From: Simon Davis
Sent: 19 December 2017 17:21
To: Planning.Responses
Subject: FW: D1304: 27 North Bersted Street BE/106/17/DOC - Planning Conditions Comments

From: Paul Cann
Sent: 19 December 2017 14:38
To: 'Lloyd Gray'
Cc: Mark Akmenkalns; Malcolm Wilkes; Jonny Ribbans ; Simon Davis
Subject: RE: D1304: 27 North Bersted Street BE/106/17/DOC - Planning Conditions Comments

Subject: D1304: 27 North Bersted Street BE/106/17/DOC - Planning Conditions Comments

ARUN DISTRICT COUNCIL REF:106157.DOC

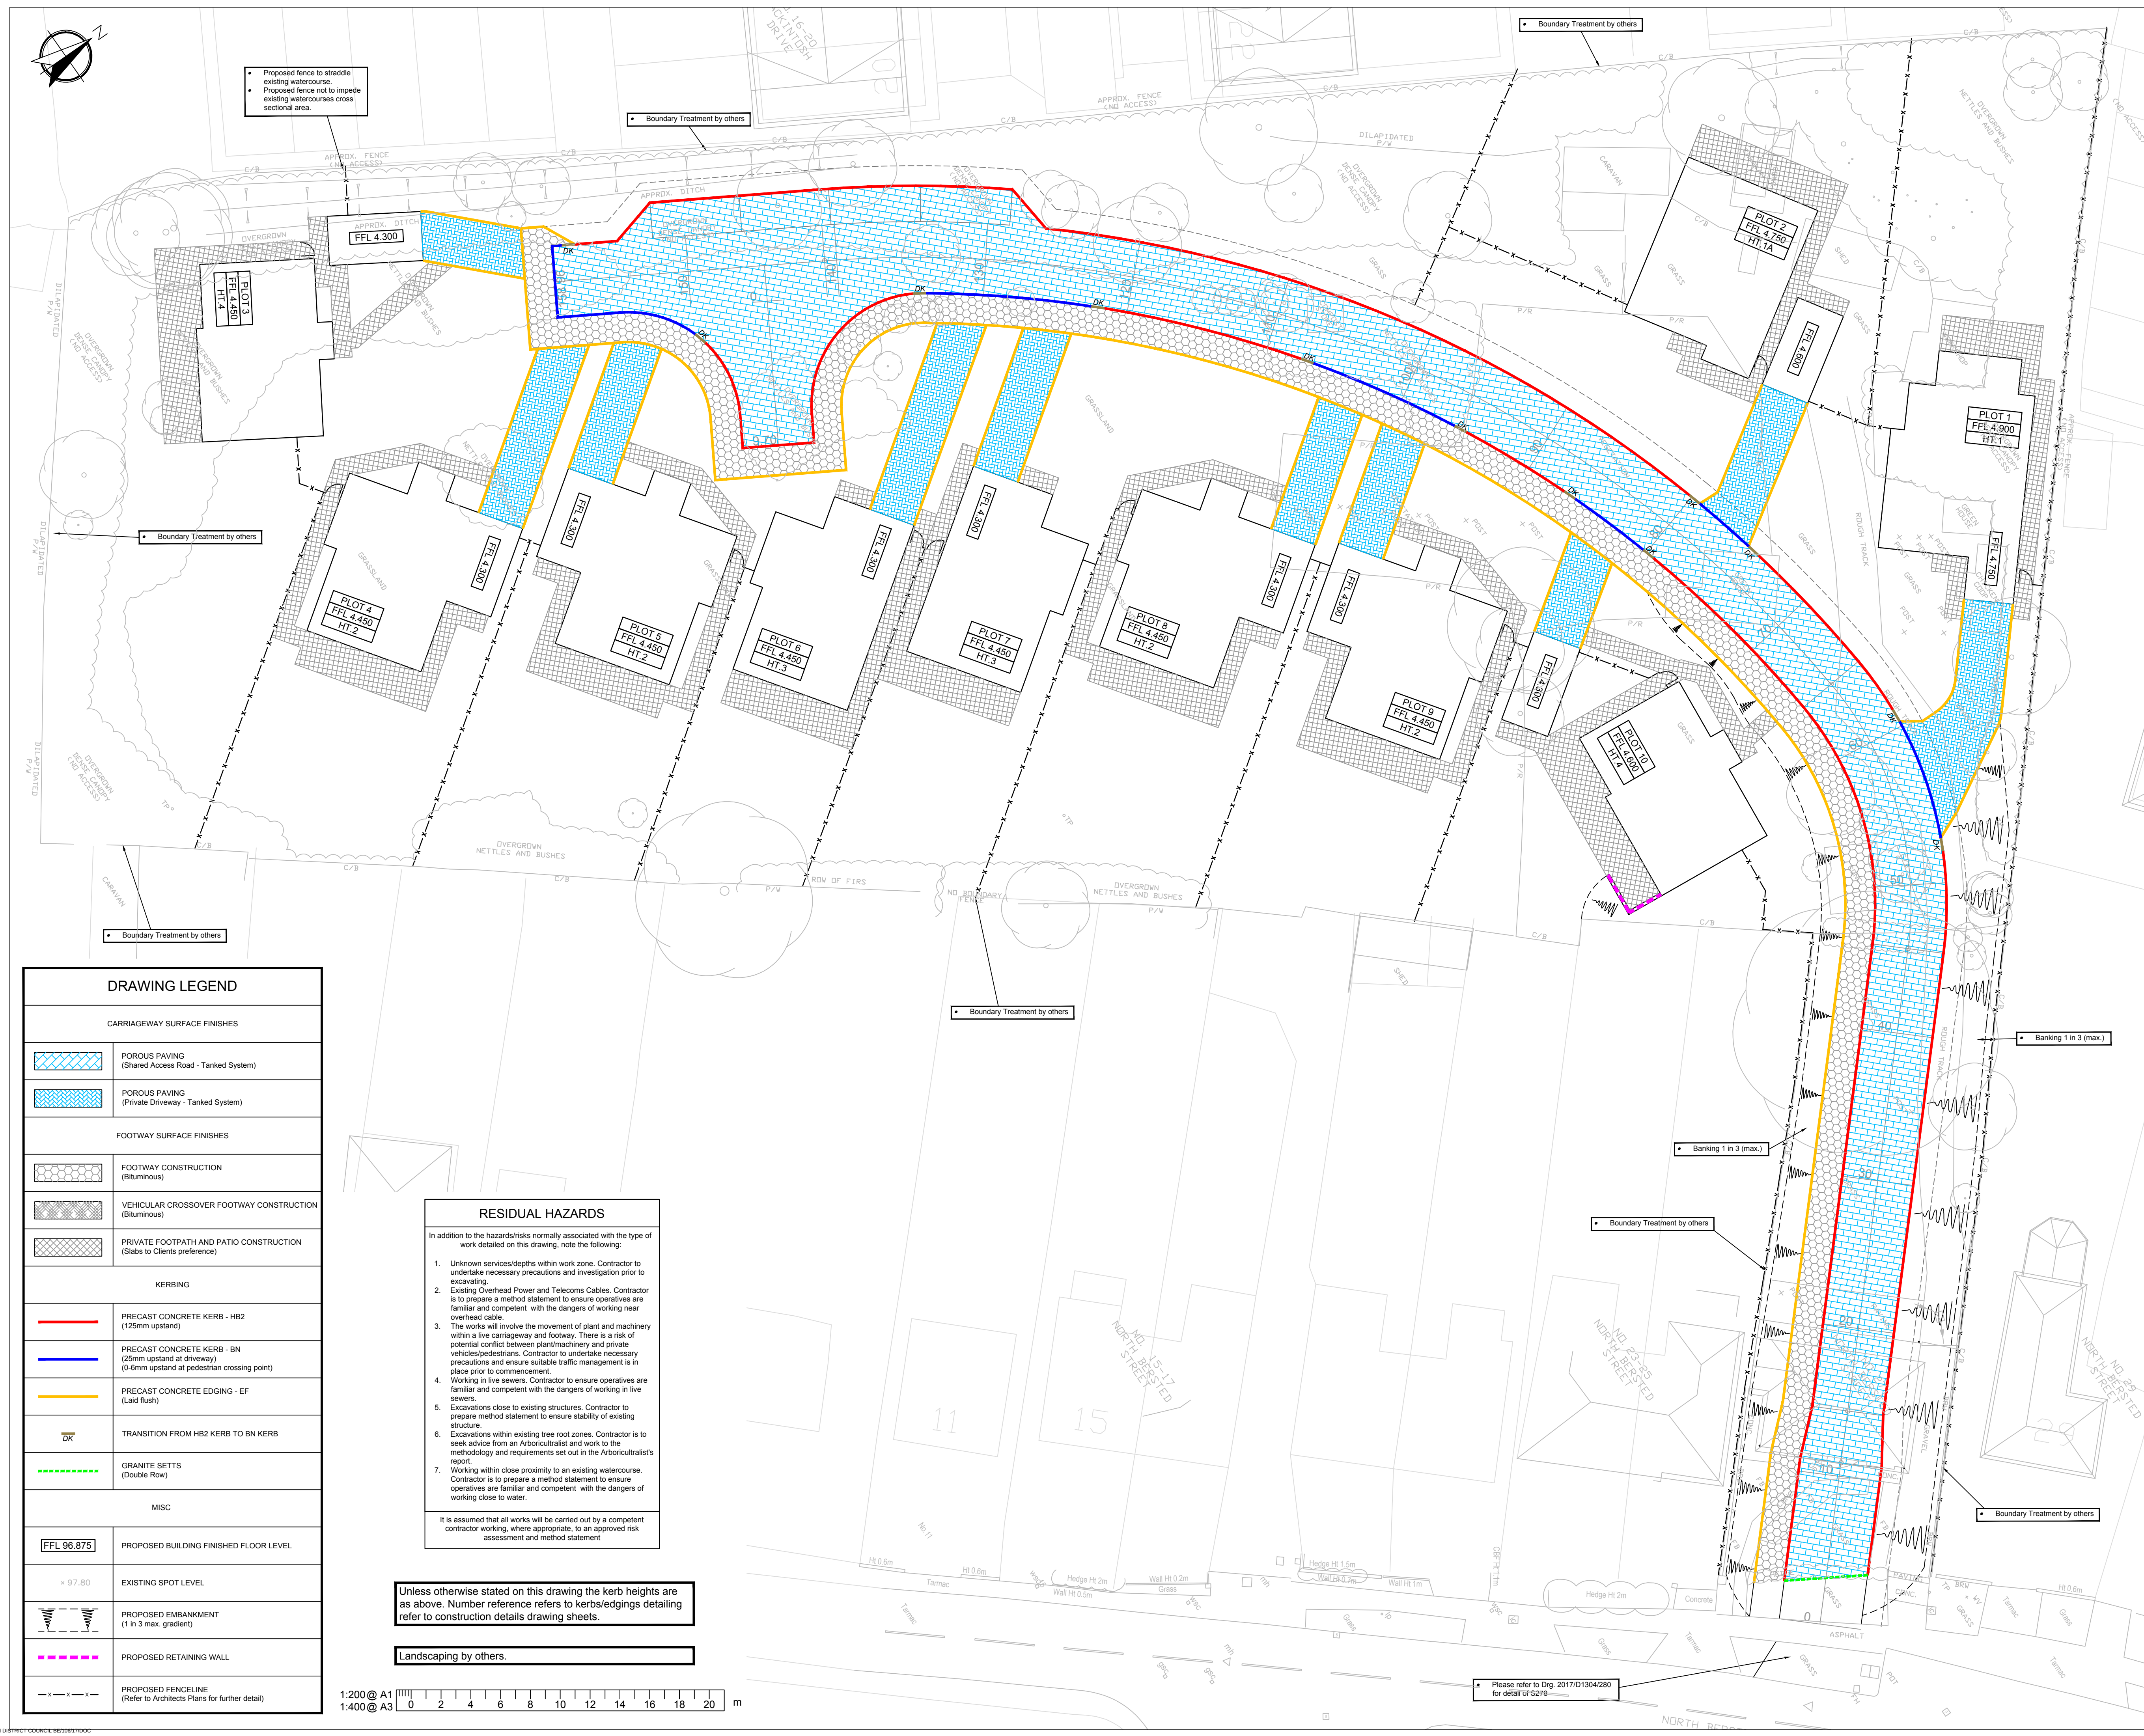
1. Please forward Southern Waters acceptance of the surface water drainage scheme following their concerns due to the proximity of foul drainage.
2. The introduction of the French drain in the vicinity of plot 3 is noted, however, please provide a construction detail.

3. As per my email dated the 11th October 2017, please improve the arrangements where the roadway storage outfalls to the adjacent catchpit chamber. I would suggest installing an additional manhole, where the two perforated pipes could be connected to it and then piped to the catchpit, as already shown.
4. Regarding the maintenance manual;
5. More details are still required in terms of the financial arrangements/funding of the management company.

1. I await the response from Southern Water in respect to your points.
2. WSCC approval to the discharge is noted.
3. Please address the items detailed in the second paragraph of my email dated the 11th October 2017.
4. Incorporate additional manholes on the permeable pavements perforated pipe ie. on head of runs. Specify cover/invert levels.
5. Hydrobrake chamber overflow -- 150mm diameter pipe required with a ramped arrangement as opposed to vertical. Utilise an oblique junction for the ramped connection to the downstream pipe section.

Drawings now acceptable.
